PLANNING CONSULTATION RESPONSE

Application No	<u>2026/0034</u>
Proposal	Outline application for the erection of one dwelling with details of access and layout (other matters reserved) (Amended Plans)
Address	Land to the West of Chapel Road, Pilley, Barnsley, S75 3AR
Date of Consultation Reply	26/08/26
Consultee	Highways Development Control

PROJECT TITLE						
79 CHAPEL ROAD, PILLEY						
DRAWING TITLE						
PRELIMINARY FOOTWAY PROPOSAL						
DRAWING NUMBER						
ORIGINATOR	PROJECT	VOL.	TYPE	ROLE	NUMBER	
PRGN	2503	HGN	DR	CH	0001B	
CLIENT						
NEIL ANTHONY						
SCALE						
1:250	A3	DRAWN	CHECKED	AUTHORISED	DATE	
		JH	LJO	LJO	JUL 26

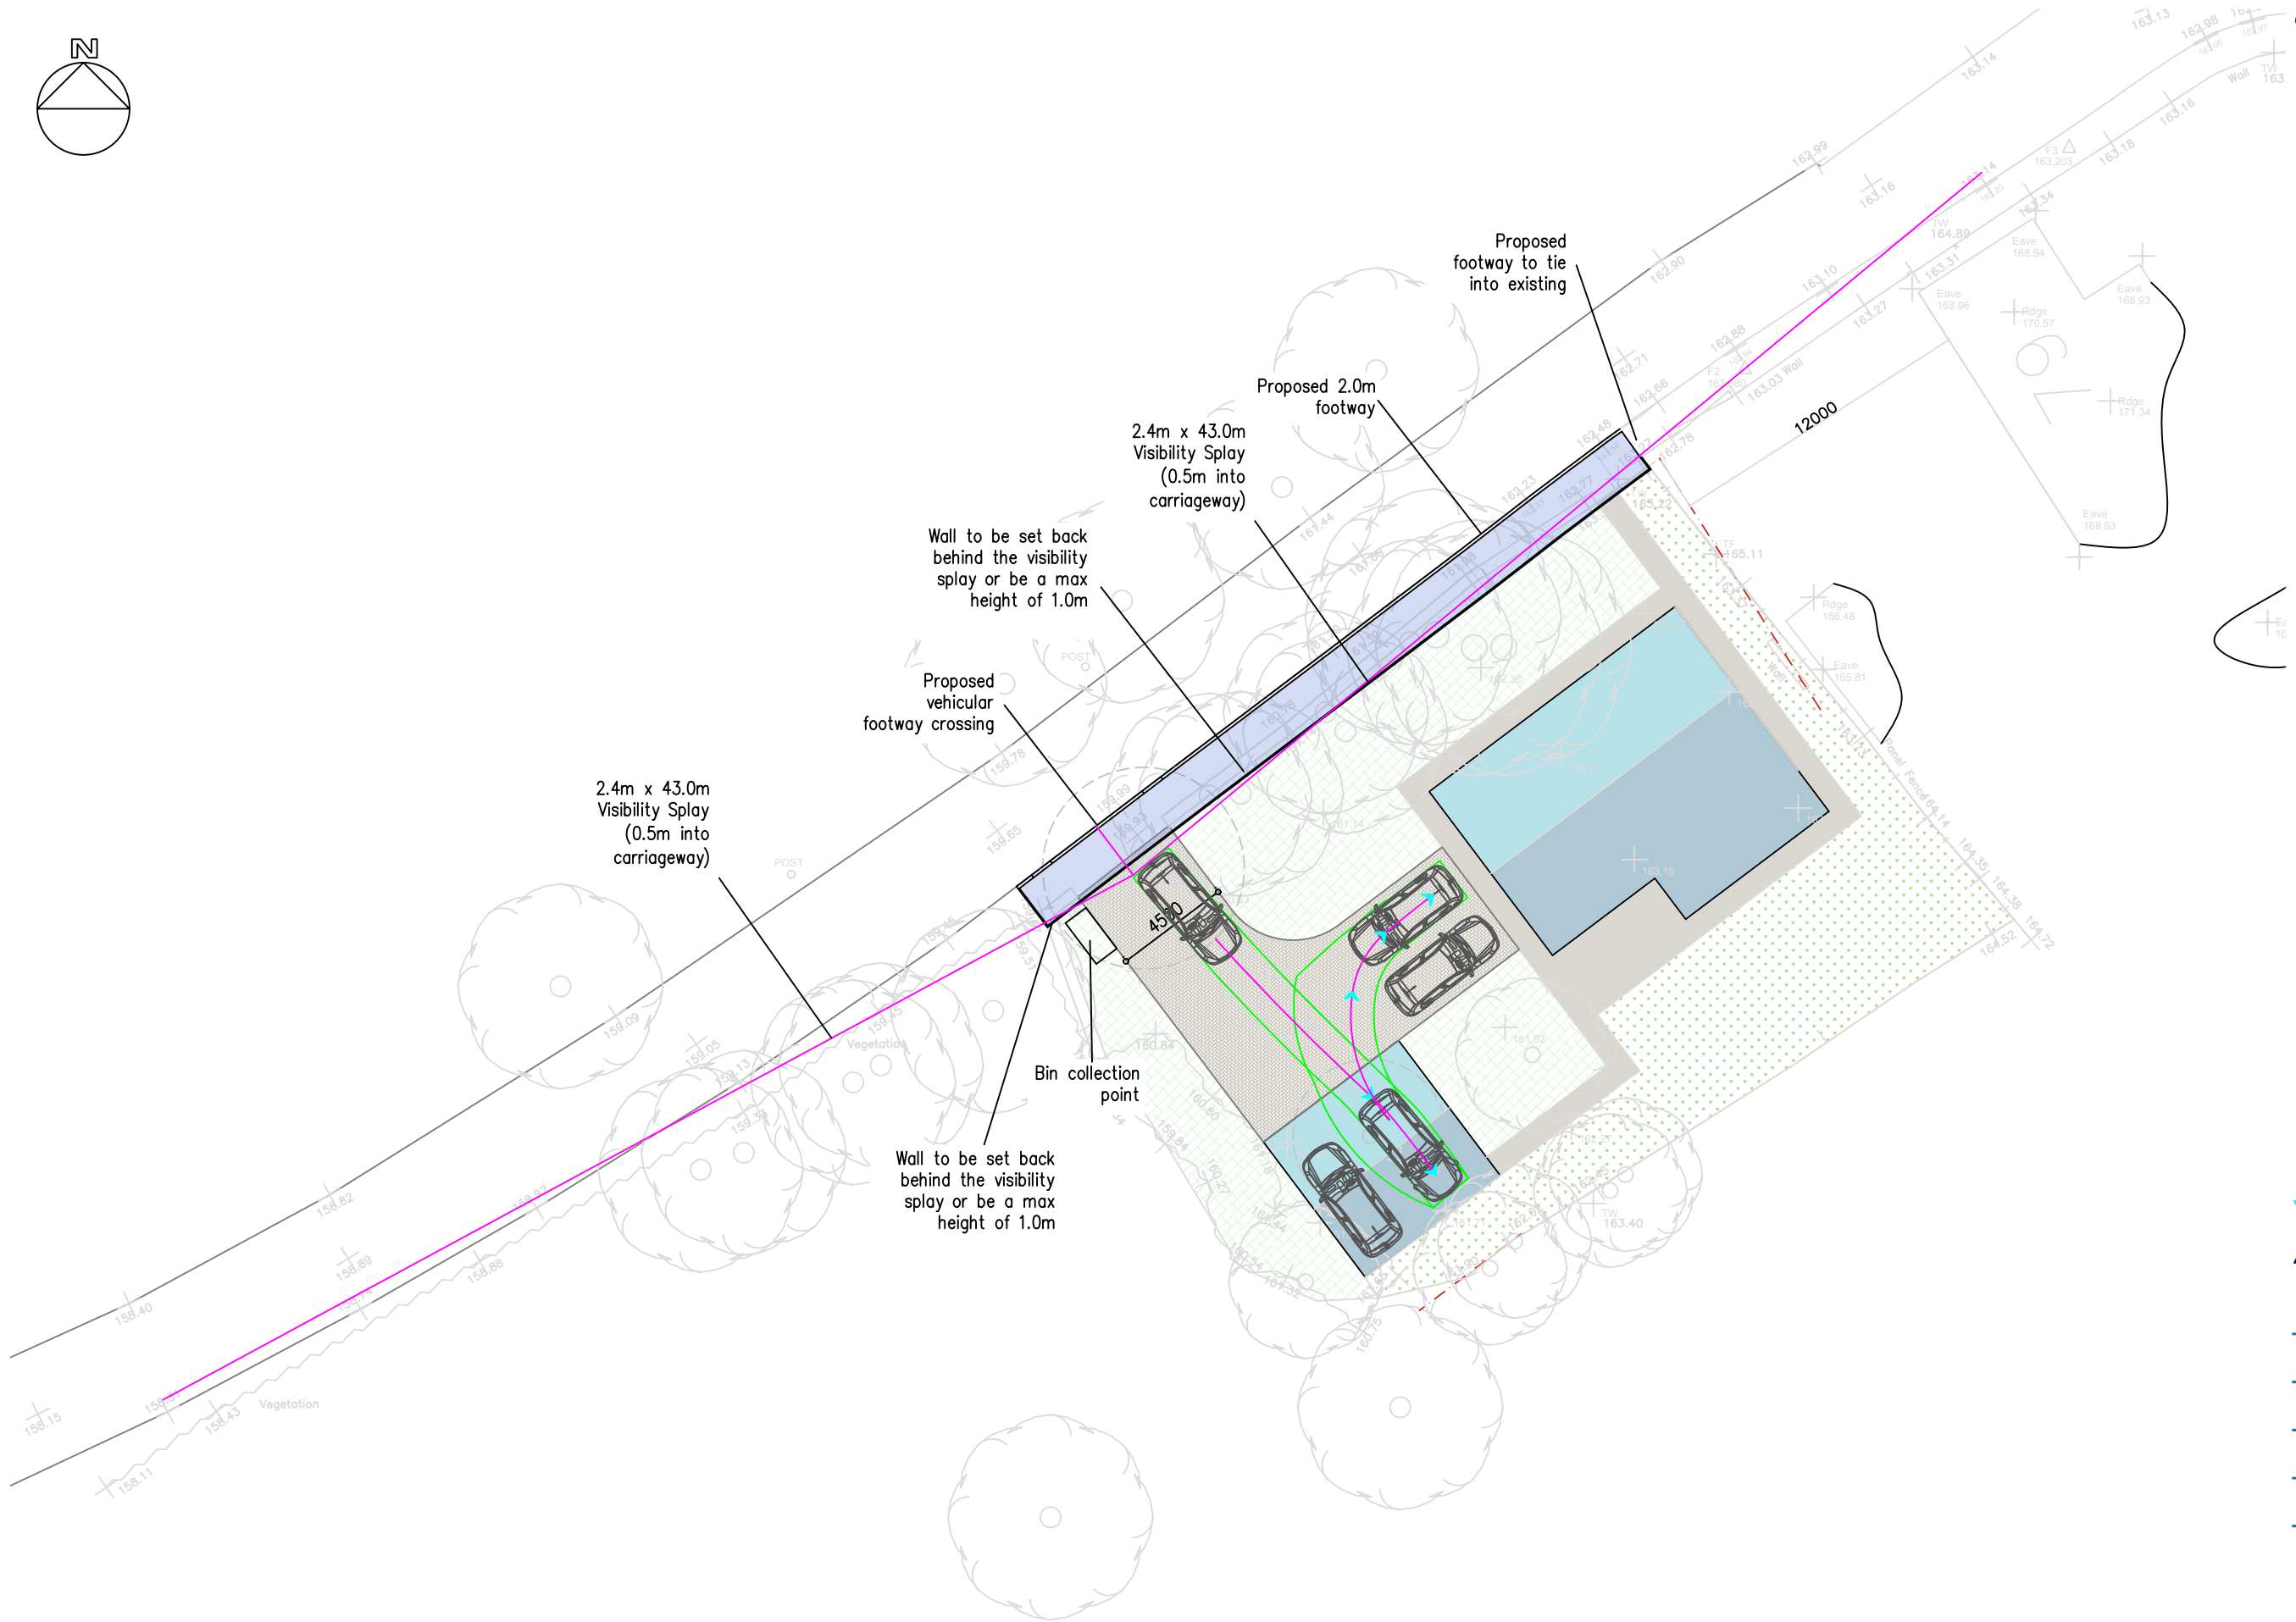
I note that the applicant has instructed Paragon Highways who have provided a transport statement. However, I am somewhat concerned that the visibility splays referred to relate to a 30mph posted speed limit.

Given that the proposed access is to be served from a road subject to a de-restricted speed limit, visibility splays should be in accordance with 60mph speeds.

In the absence of such evidence, speed surveys should be undertaken in accordance with the requirements of DMRB CA 185 to establish the 85th percentile wet-weather vehicle speeds and justify any reduced visibility requirements.
